COMMUNITY SERVICES DEPARTMENT

September 15, 2021

Subject: Eagle Forest Filing No. 1 Final Plat – (SF2131)

EAGLE FOREST SUBDIVISION FILING NO. 1

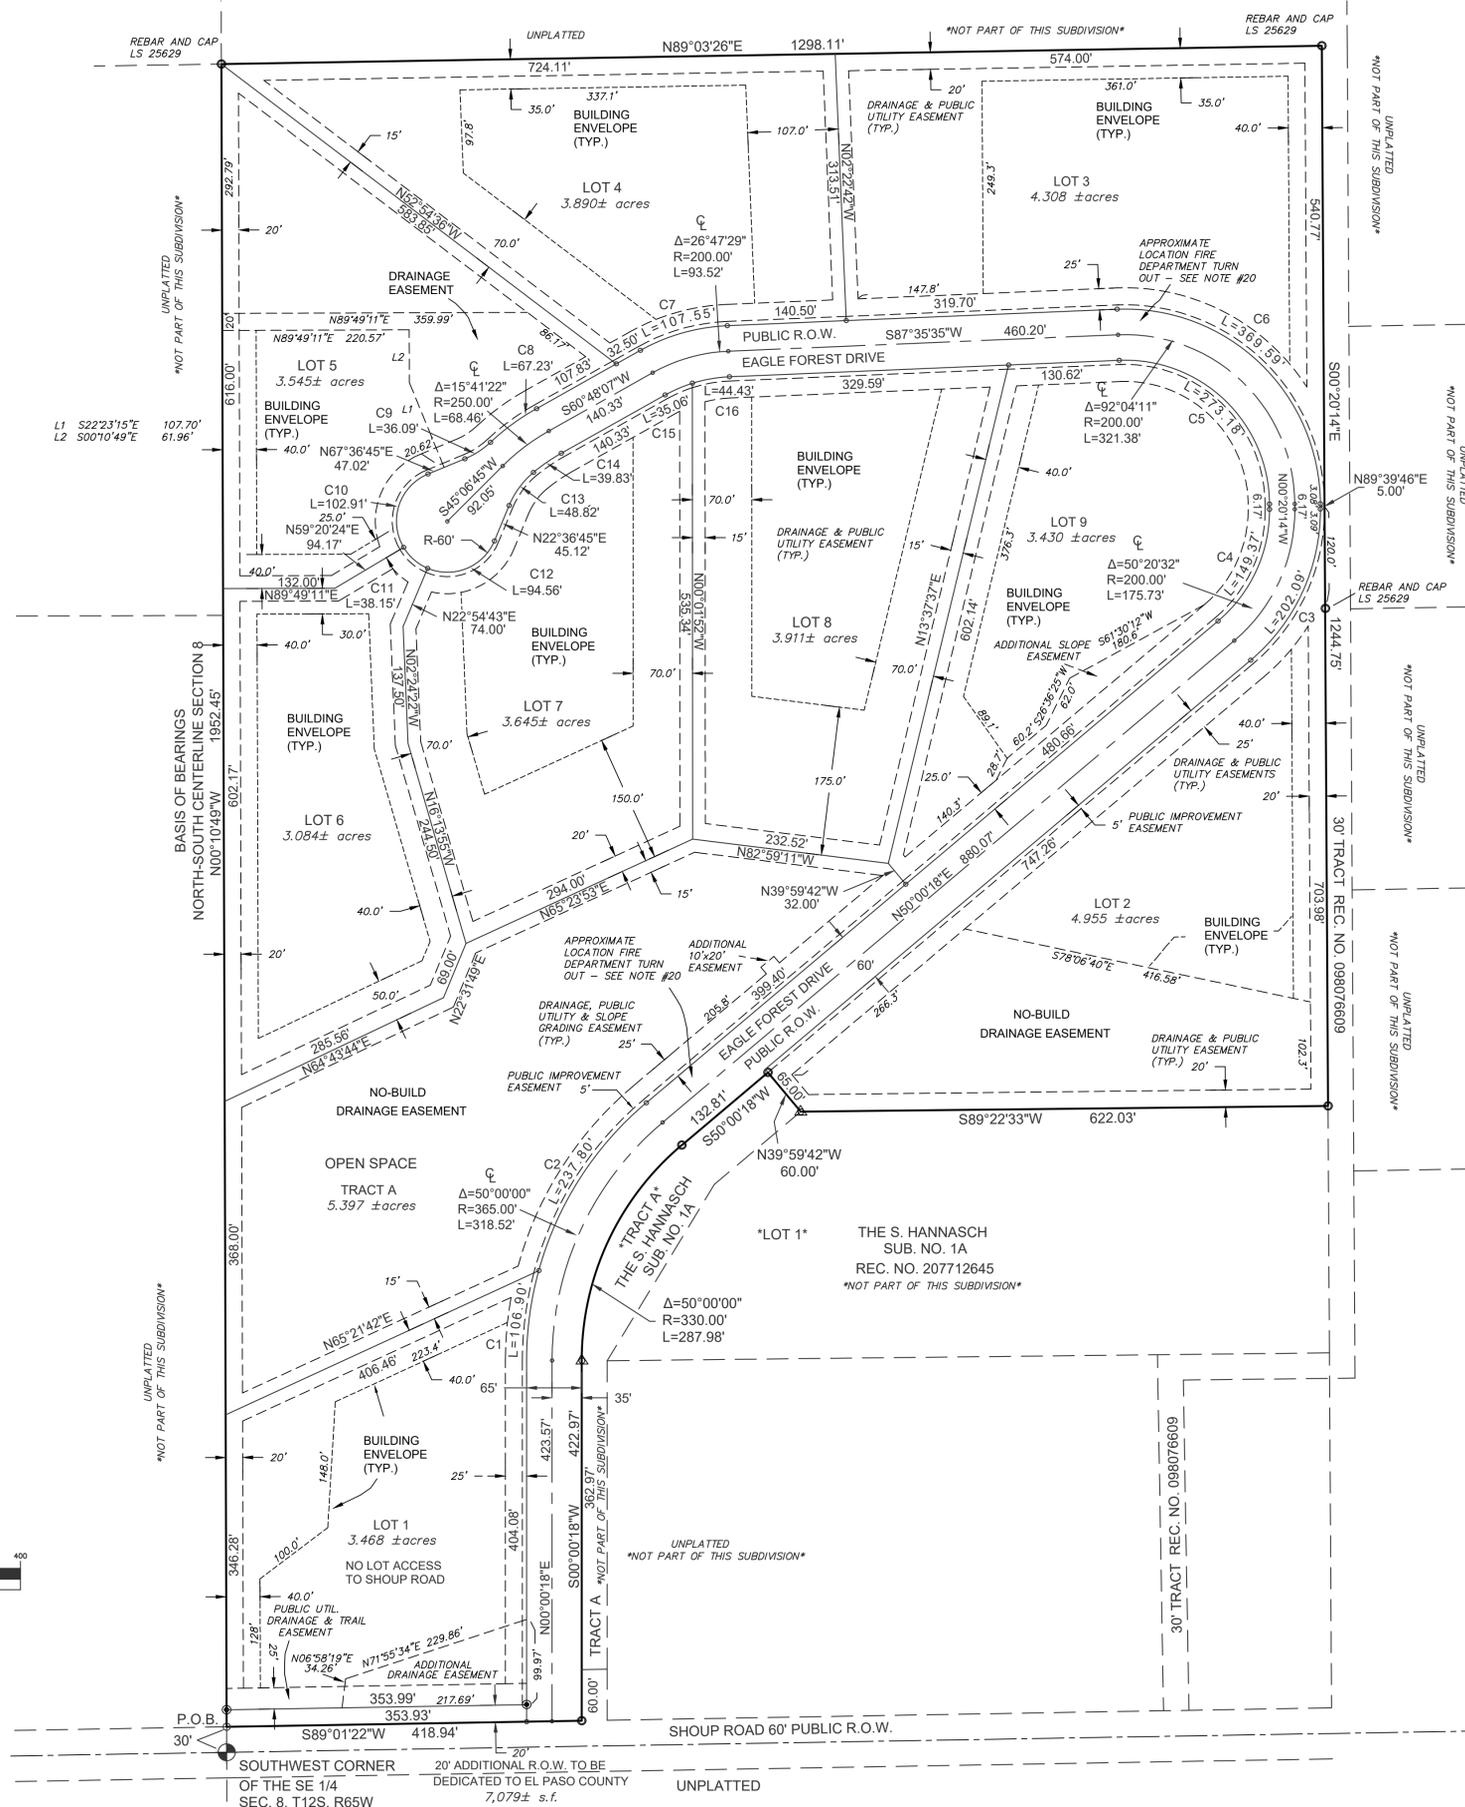
Bicycle Route is not impacted by the project because it is located in the public right of way. The proposed Black Forest Primary Regional Trail along Shoup Road is within the project area on the north side of Shoup Road. The letter of intent mentions that a 25-foot trail easement will be dedicated to El Paso County along Shoup Road however, the easement is not shown on the final plat drawings.

County Parks requests trail easements where development projects impact proposed County trails. As it pertains to this application, the County requests that the applicant provide a 25-foot public trail easement along the north side of Shoup Road that allows for the construction and maintenance by El Paso County of the Black Forest Primary Regional Trail, and this easement shall be shown and dedicated to El Paso County on the Final Plat.
